EXQ1 Reference	North Kesteven District Council Response
GEN.1.10	<p data-bbox="450 272 584 300">APP-175</p> <p data-bbox="450 347 2029 671">As set out in North Kesteven District Council’s LIR, Springwell NSIP solar park (situated in North Kesteven) is noted as an ‘unregistered’ project as at the December 2022 report finalisation date (as is the Lincolnshire Reservoir NSIP, also in North Kesteven), and neither the Beacon Fen or Fosse Green solar parks are noted given that they were announced in March and May 2023 respectively, and have both subsequently been subject to EIA Scoping decisions issued by the Planning Inspectorate. APP-175 is therefore out of date as it does not reference the Beacon Fen and Fosse Green NSIP proposals. In addition, the One Earth Solar Farm, located partly in West Lindsey District in Lincolnshire has also since been registered as an NSIP project - EN010159. The other registered NSIP solar projects in West Lindsey have all since progressed to varying stages including some in examination.</p> <p data-bbox="450 719 2029 927">Furthermore, the Lincolnshire Reservoir (project 32 listed in APP-175) has since been registered and assigned NSIP reference numbers WA0

FIGURE 10.1 DESIGNATED HERITAGE ASSETS

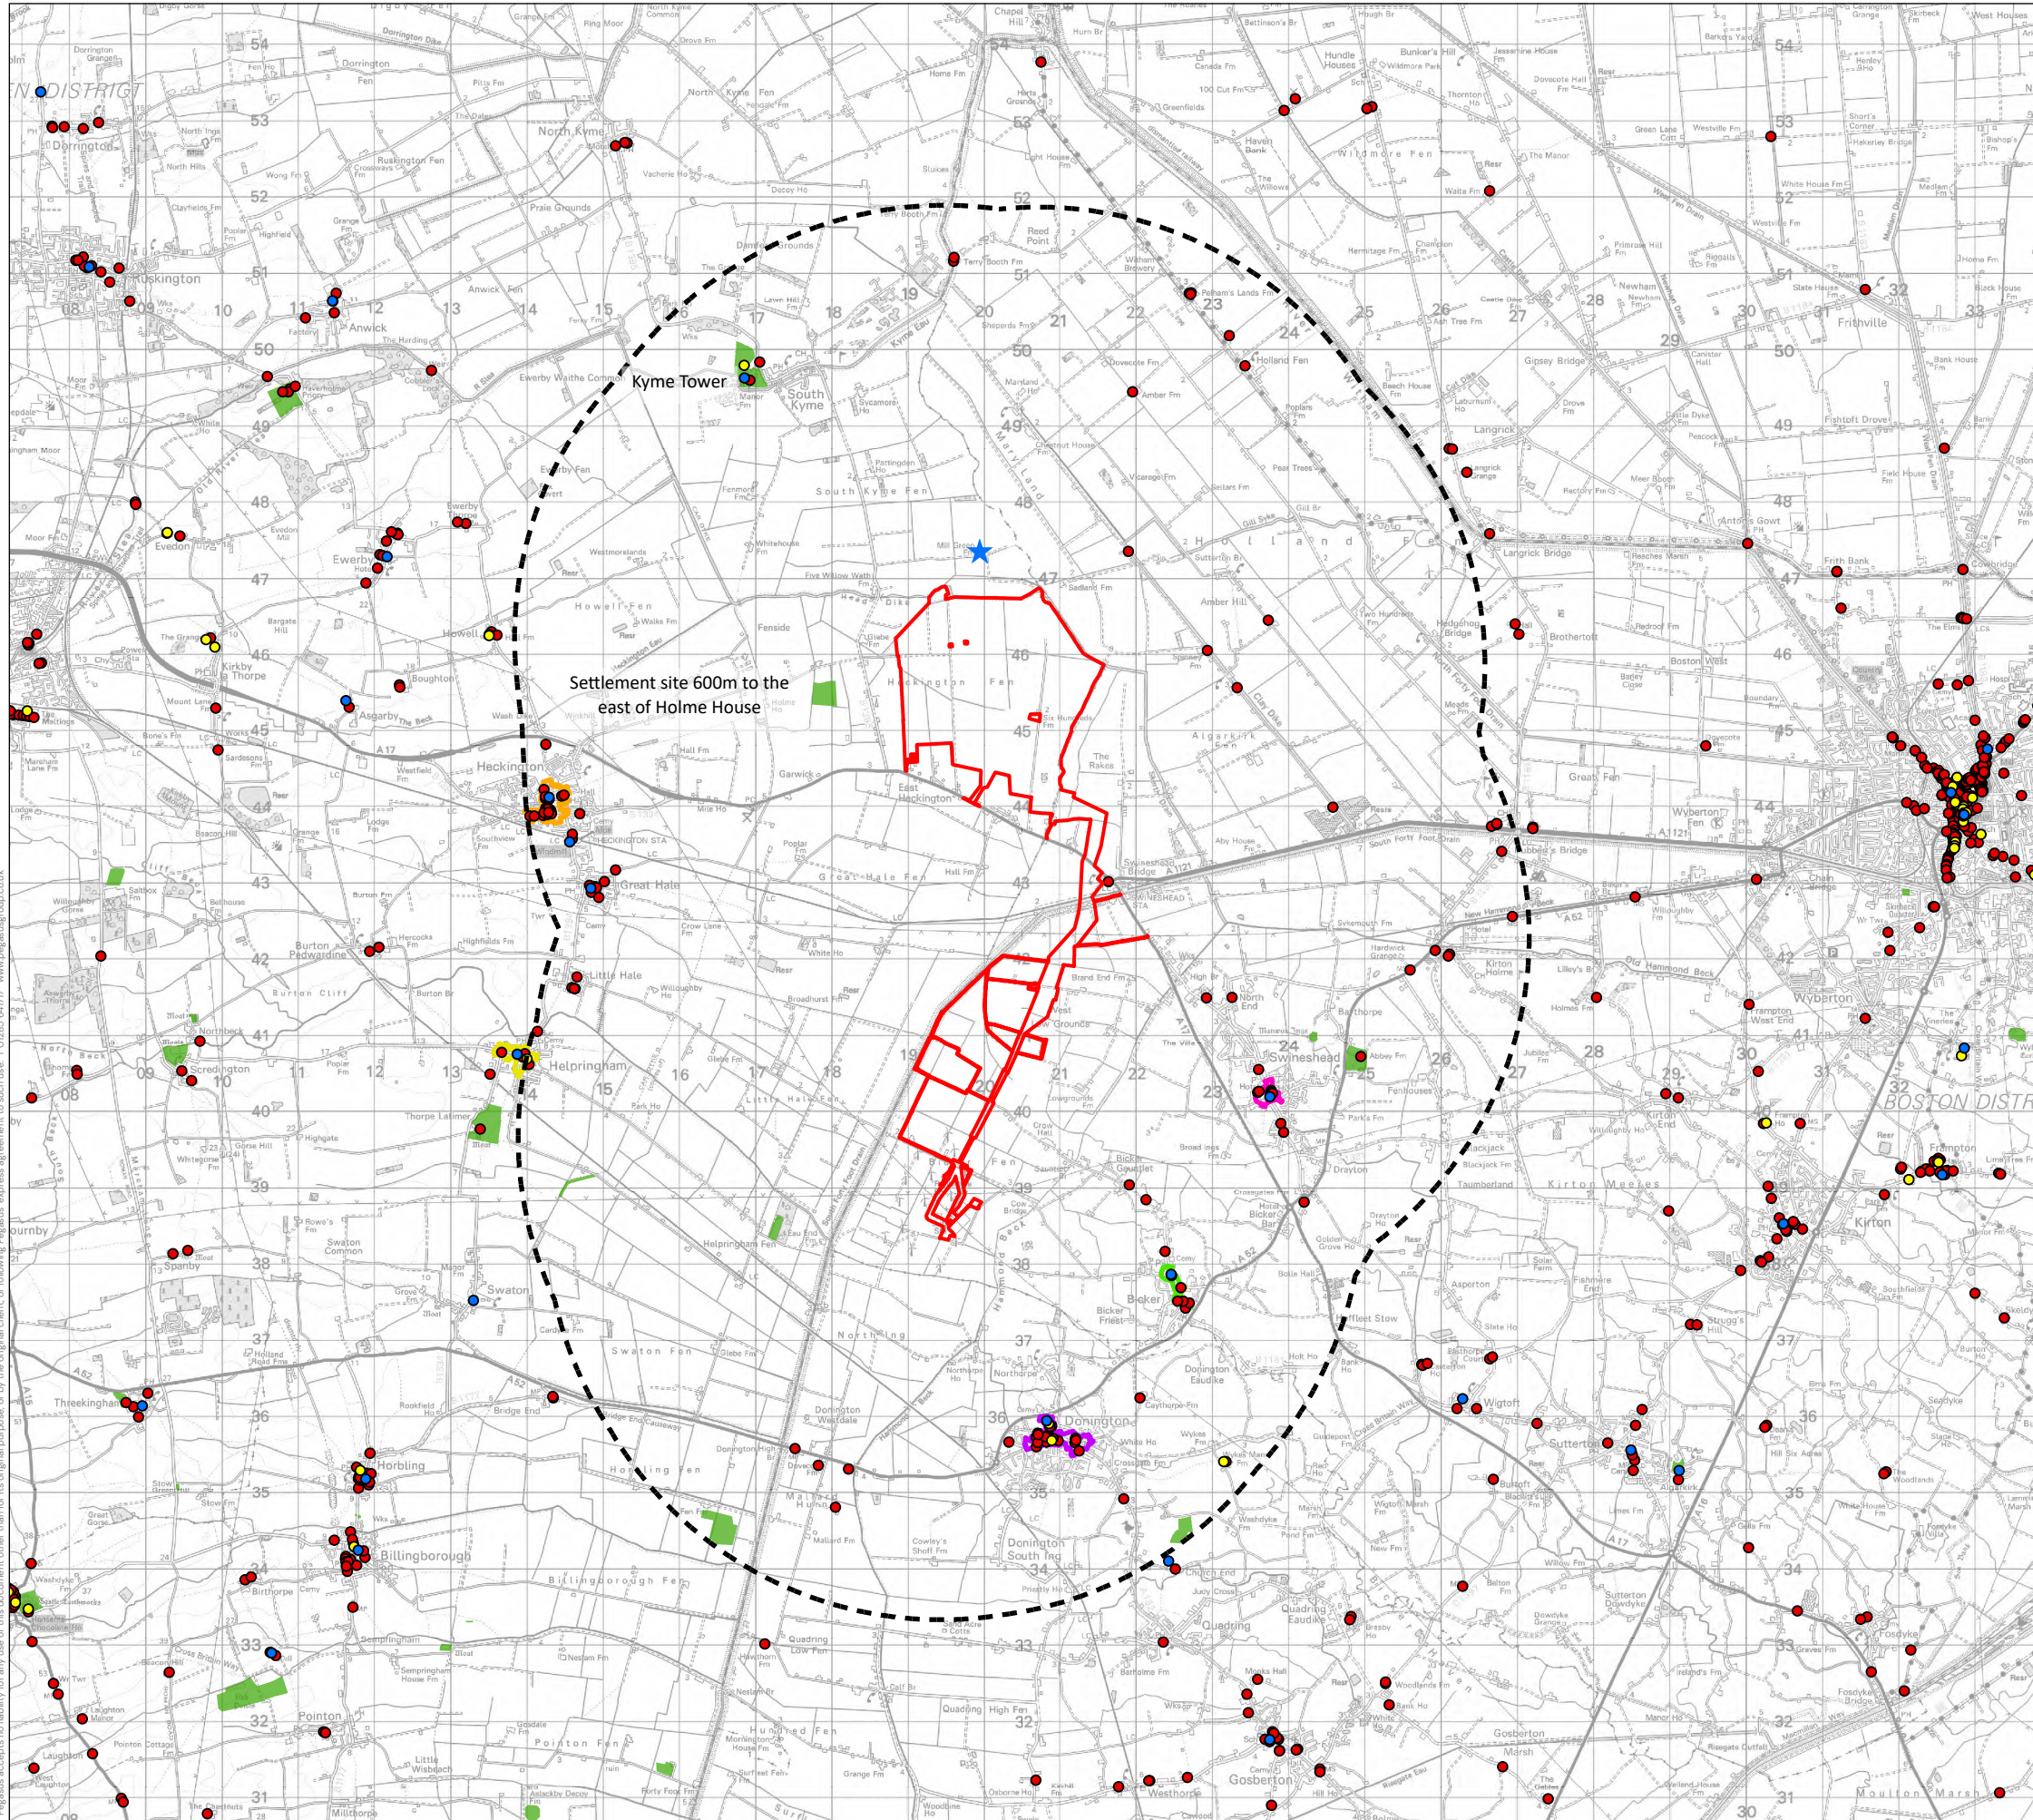
In terms of above ground heritage assets, we agree that there appears to be no historical or direct visual association between Mill Green Farmhouse and the land proposed for the Beacon Fen site and therefore do not consider there to be cumulative effect with this non-designated heritage asset. Views of Kyme Tower are possible from areas around the north west of Beacon Fen and as such, mindful of the Council's position in relation to the assessment of Kyme Tower in relation to the main energy park site, some cumulative adverse effect cannot be ruled out albeit we accept that no such assessment has yet been provided in relation to the Beacon Fen scheme.

With reference to impacts on Kyme Tower, the Council's principle concern lies with the following description of the setting of the tower in paragraph 6.59 of the Environmental Statement (Volume 3: Technical Appendices Appendix 10.1: Heritage Desk Based Assessment DBA) (APP-206);

As a fortified tower there should not be an expectation that the tower was designed as part of a wider designed landscape. The tower was constructed to be both conspicuous in the landscape and functionally offering a 360-degree defensive view away from the tower. The principal of aligning its significance within a designed view/designed landscape would be to imply that it was a folly type structure, which is not the case. These views and the surrounding landscape add significance to the setting of the heritage asset. The application site falls within these views.

Due to the historic function of the tower and the extant landscape setting, no views of the tower, or away from the tower, should be classed as "incidental". The fact that the tower is visible from the application site demonstrates the fact that Kyme Tower was designed to be a physical presence in the landscape.

The application site would be visible and present within views away from the tower, thereby affecting the landscape character of the site, though this is yet to be properly assessed through the application. This would affect the setting of the tower, thereby having a degree of 'less than substantial harm' on its special interest. The impact of monumental architecture in the landscape is further exemplified by views of numerous church towers and spires located outside the study area, which are still clearly visible from the application site.

As such the Council disagrees with the conclusion in paragraph 10.5.22 of APP-063 that the effect on Kyme Tower is "not significant" and that no harm is caused. In our view, we believe that the impact has yet to be fully assessed, however we accept that the harm lies towards the lower end of 'less than substantial' (engaging NPPF paragraph 202) however that the required counterbalance of public benefit would be met.

FIGURE 2.2a CUMULATIVE SITES- SHORTLISTED (REGIONAL CONTEXT)

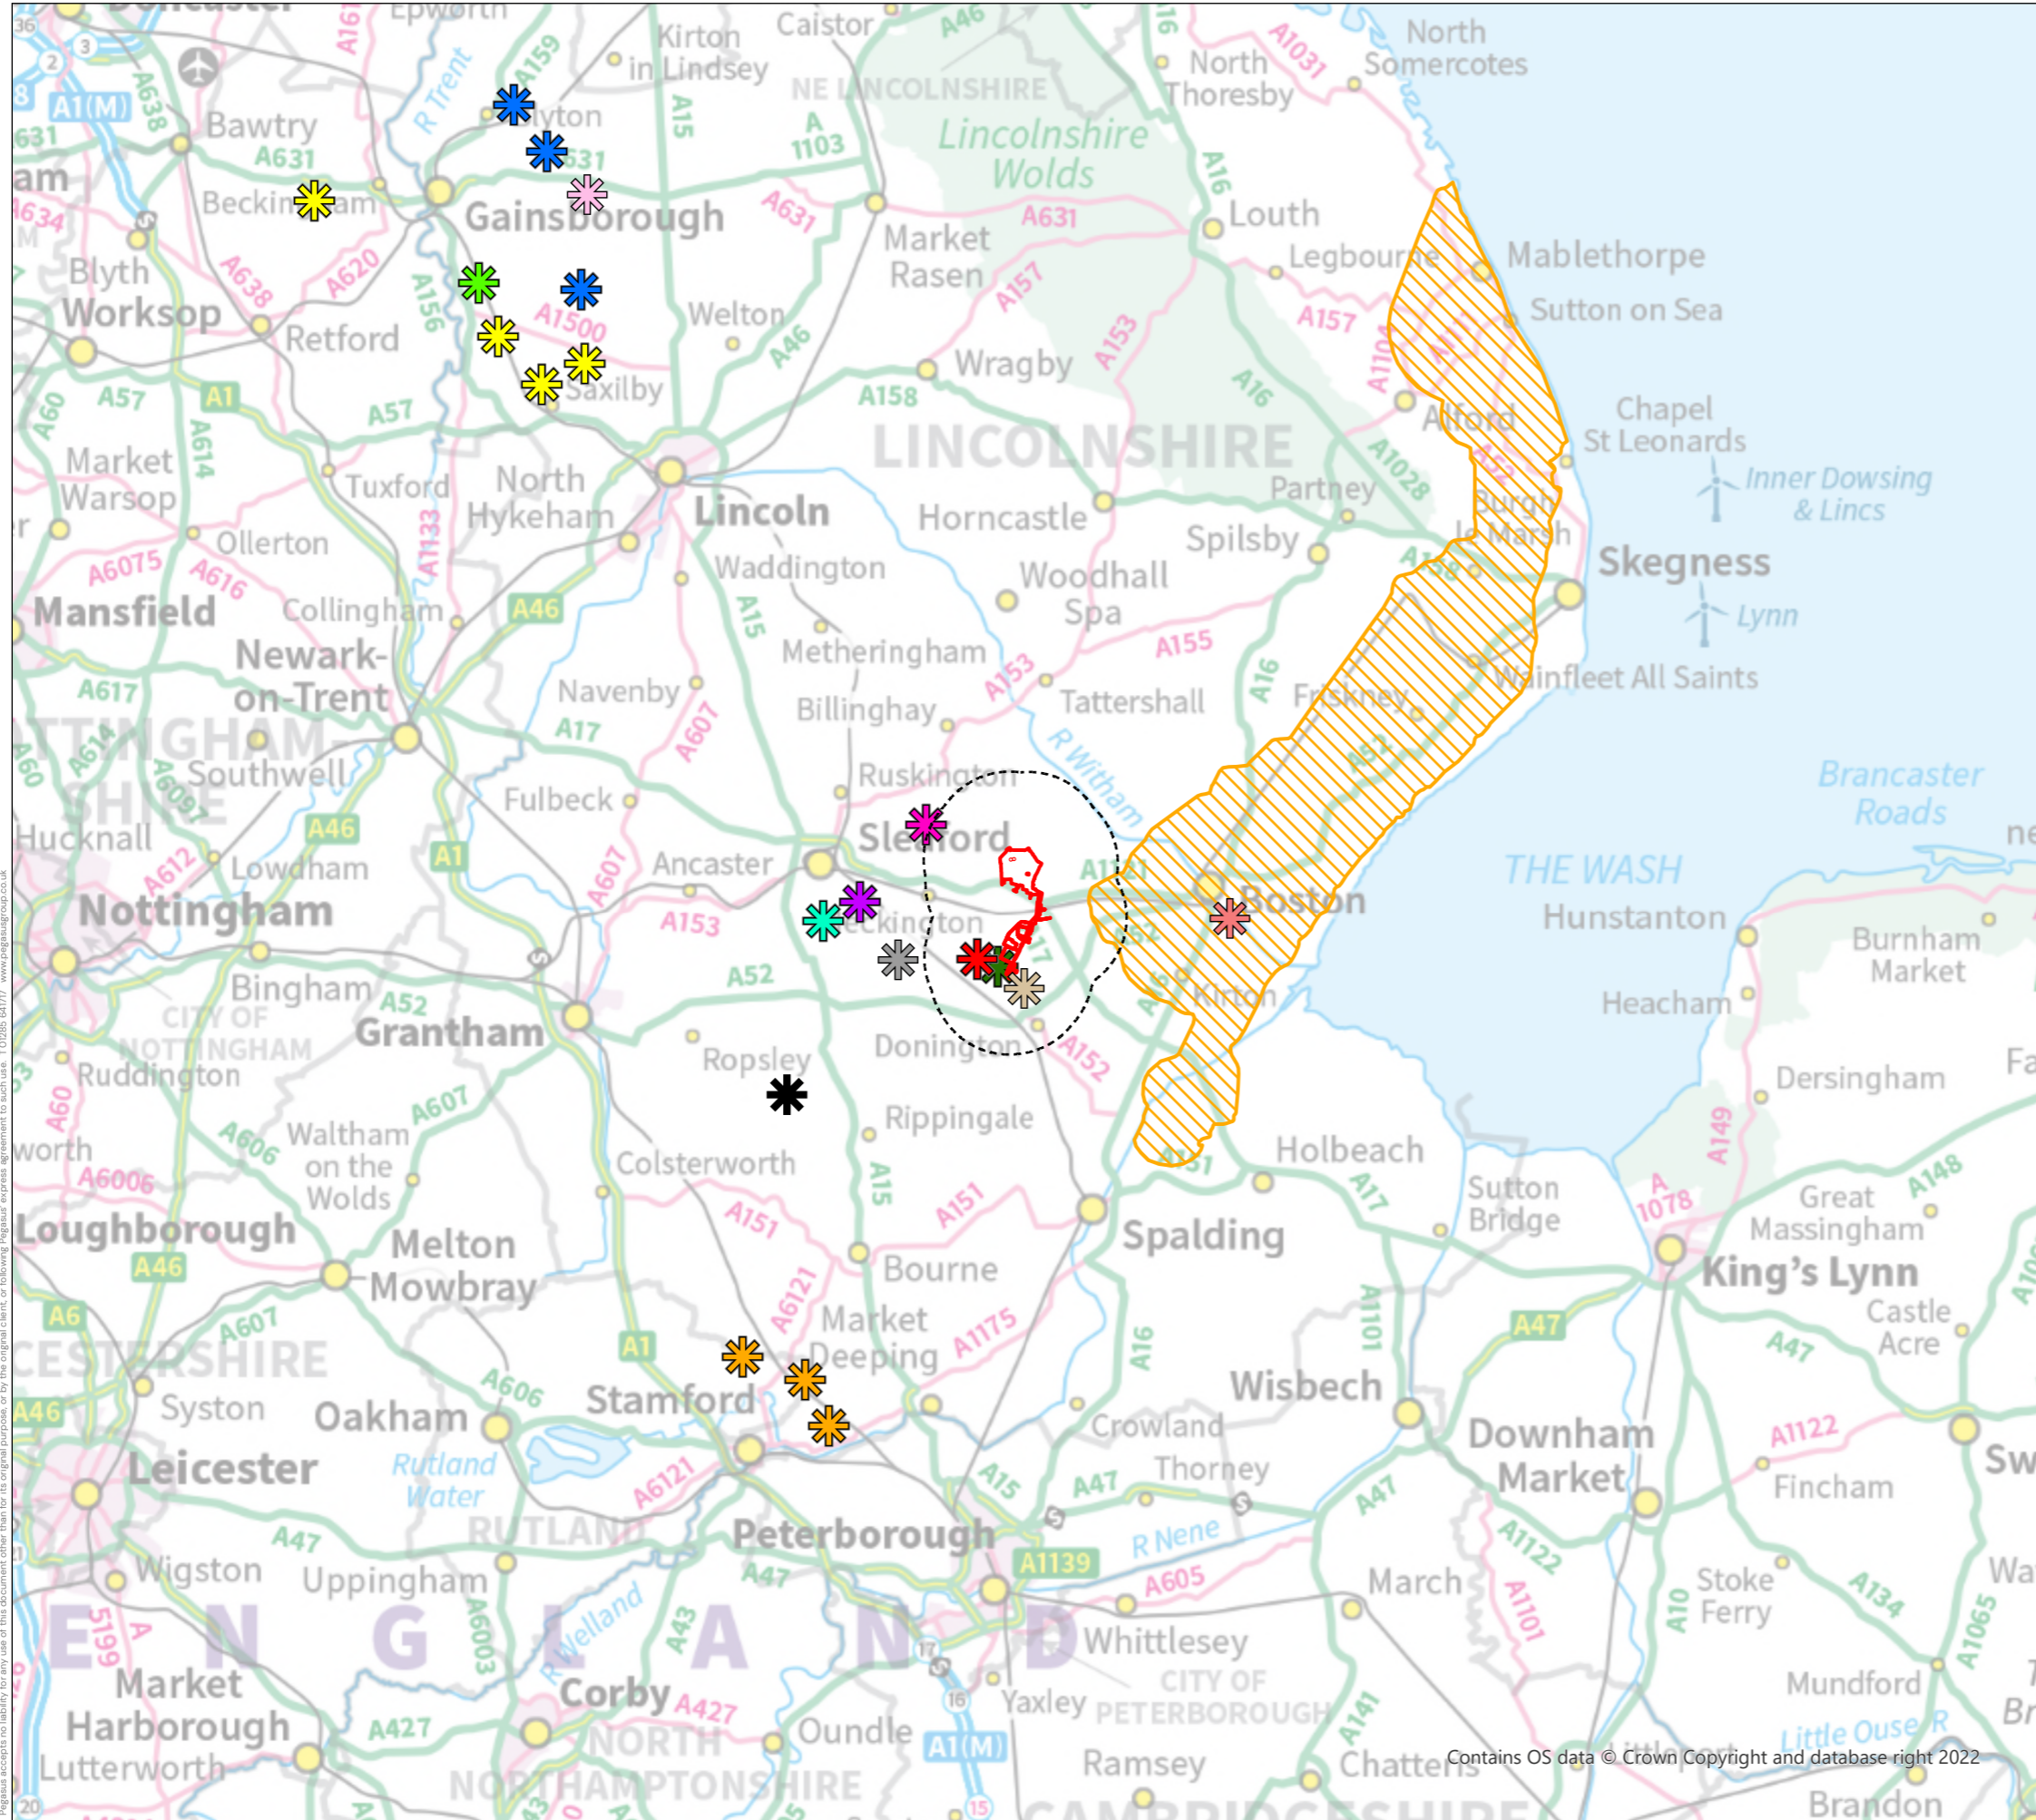
With reference to Table 1.1 'Initial assessment of other projects with potential cumulative effects' and specifically projects 1, 2, 4, 5, 6, 8, 9, 10, 11, 12 and 13 (NSIP schemes) the Council does not agree that cumulative agricultural land/BMV impacts will not be significant. This matter is also raised in the Council's LIR and Written Representation. Consistent with our LIR (Table 25.1) the Council agrees that cumulative impacts of Heckington Fen taken alongside the named solar NSIP projects in Lincolnshire (supplemented now by the One Earth solar project) will be 'neutral' for the other topic areas set out in that table, save for positive socio-economic effects across all named projects. The exception is Beacon Fen energy park where our LIR identifies potential (negative) cumulative effects in relation to BMV land, LVIA, cultural heritage and transport.
